PRE-HEARING STAFF ANALYSIS

Rezoning Petition No. 2008-060

Petitioner: Gandy Communities

Location: Approximately 21.22 acres located on the east side of Point O'Woods Drive and the west side of Northlake Centre Parkway

RZ-4.0

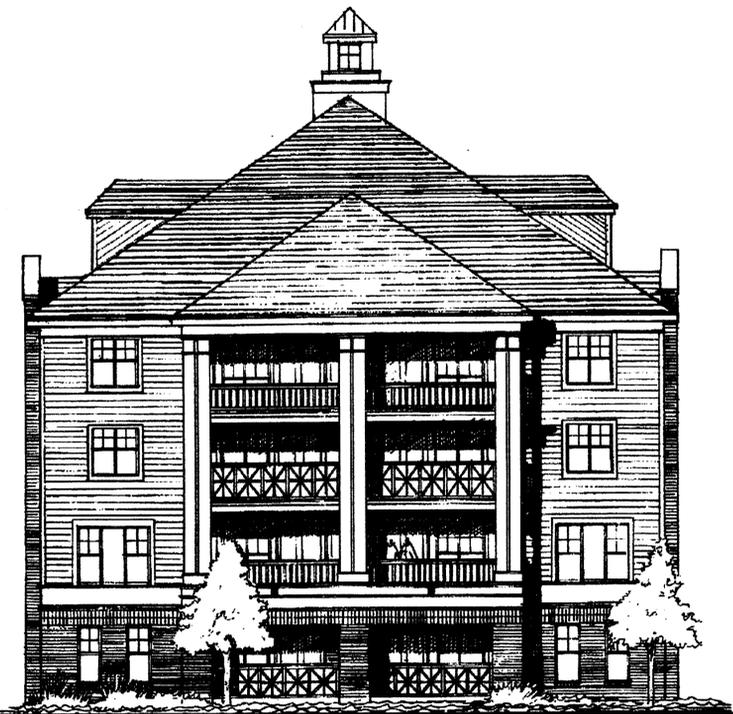
The office/retail buildings should not have expanses of blank walls exceeding 20-feet.

RZ-2.0

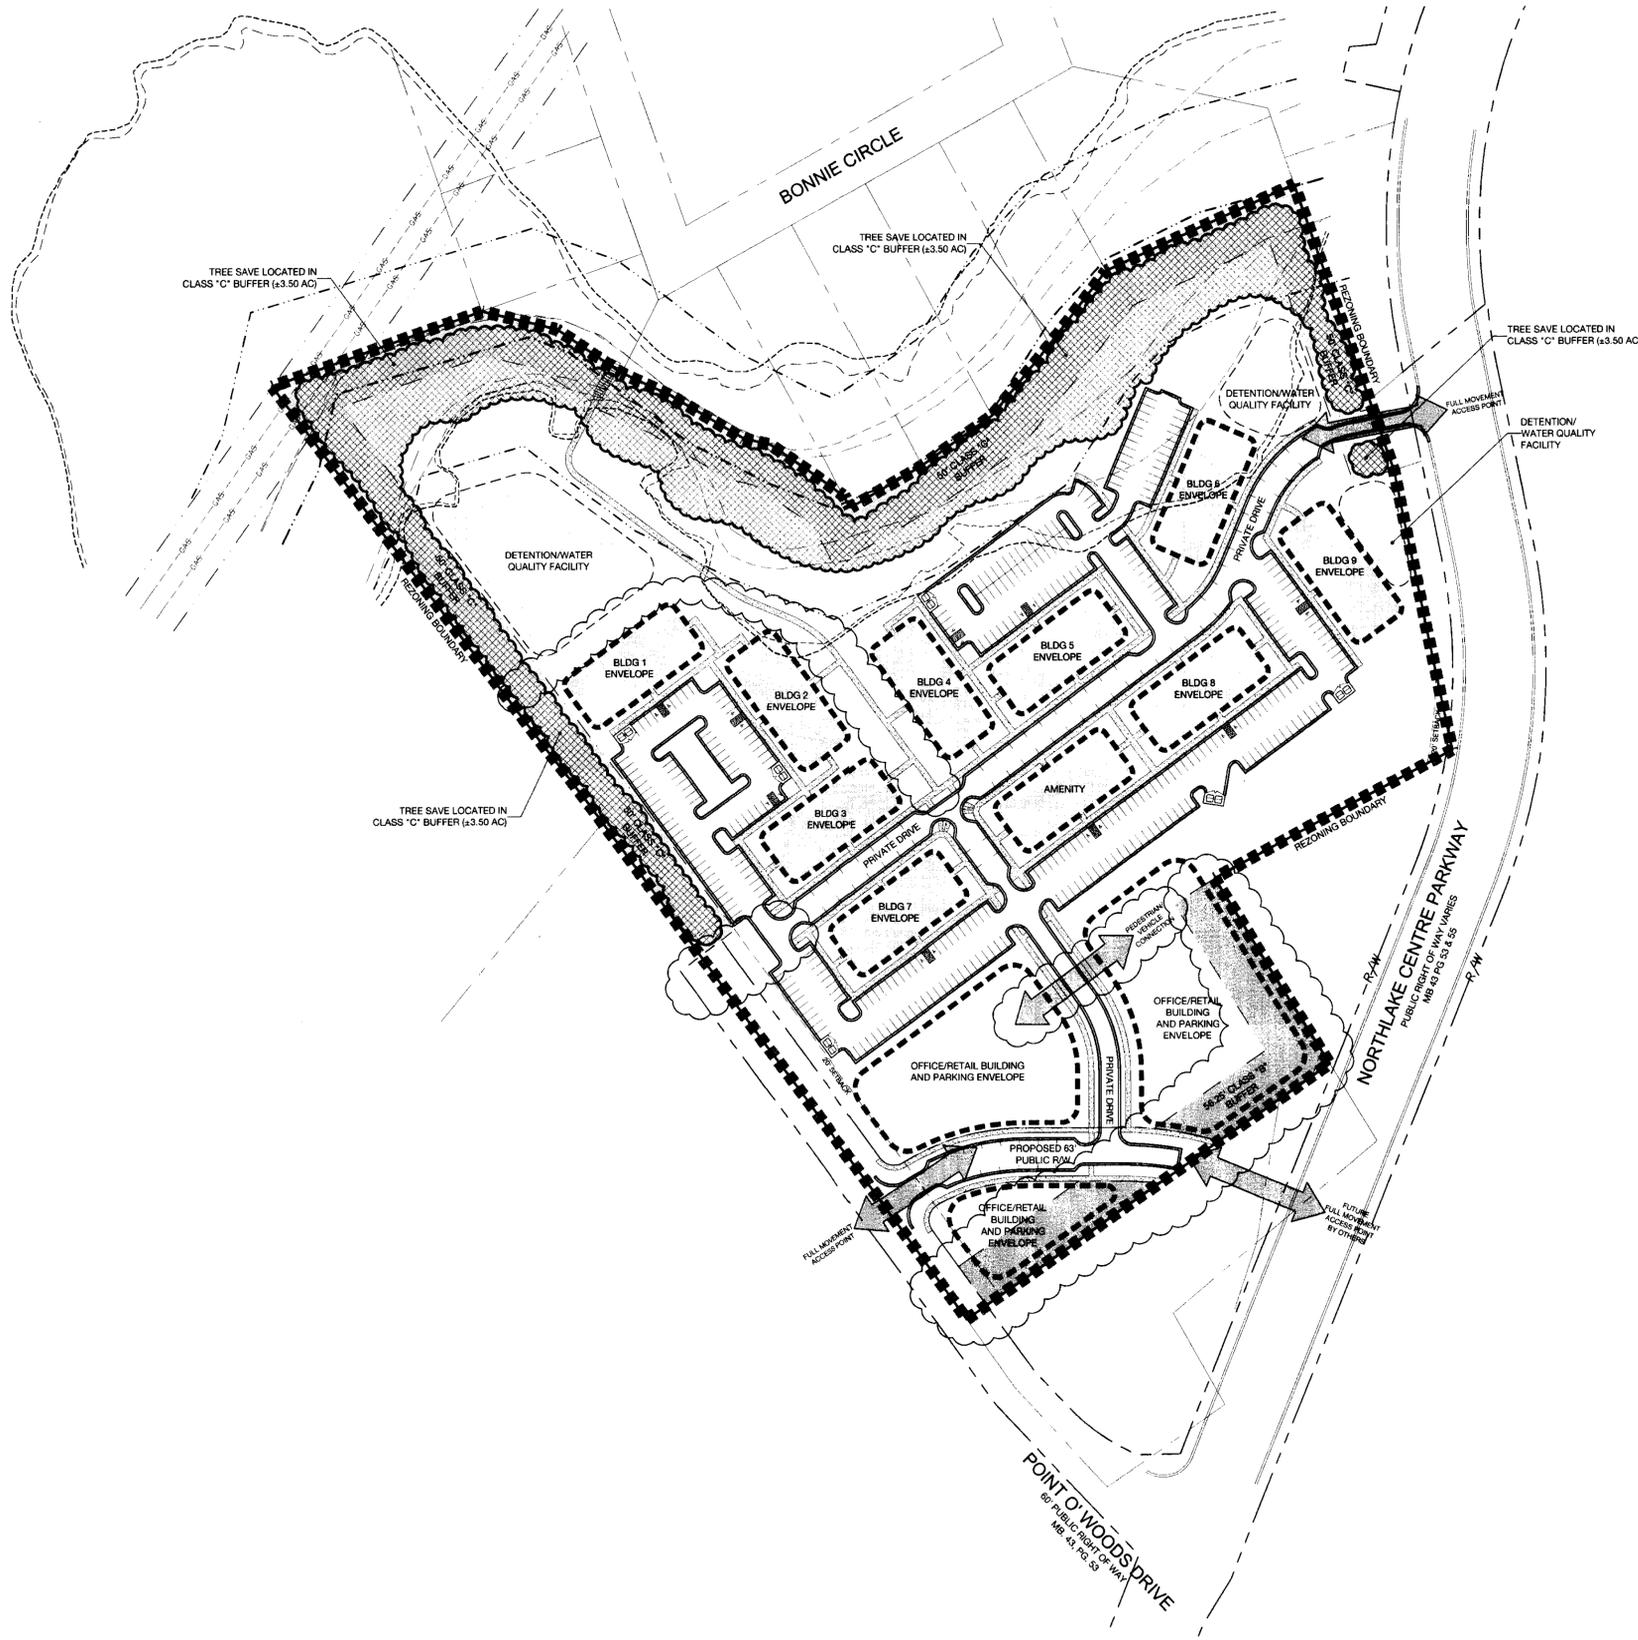
Upon extension of the proposed 63-foot right-of-way/street located on the south side of the site to Northlake Centre Parkway, the existing portion of Point O' Woods Drive between Northlake Centre Parkway and the southern stub to the Northcrest Shopping Center needs to be removed and a petition submitted to the City for abandonment. (*Previous review comment*)

The maximum building height in feet should be shown in addition to the number of stories. The non-residential building should be limited to 40-feet in height unless additional side yards are provided where adjoining residential uses.

The floor area ratio should be noted on the plan and must be less than 1.0.

Detention should not be located within the buffer areas.

The note indicating that the Class "C" buffer to the rear of the property may be eliminated if the property owner dedicates the land to Parks and Recreation for greenway purposes [Section 12.302(13)] should be on the plan

A pedestrian connection should be provided from residential building #9 to the adjacent property fronting on Northlake Centre Parkway.
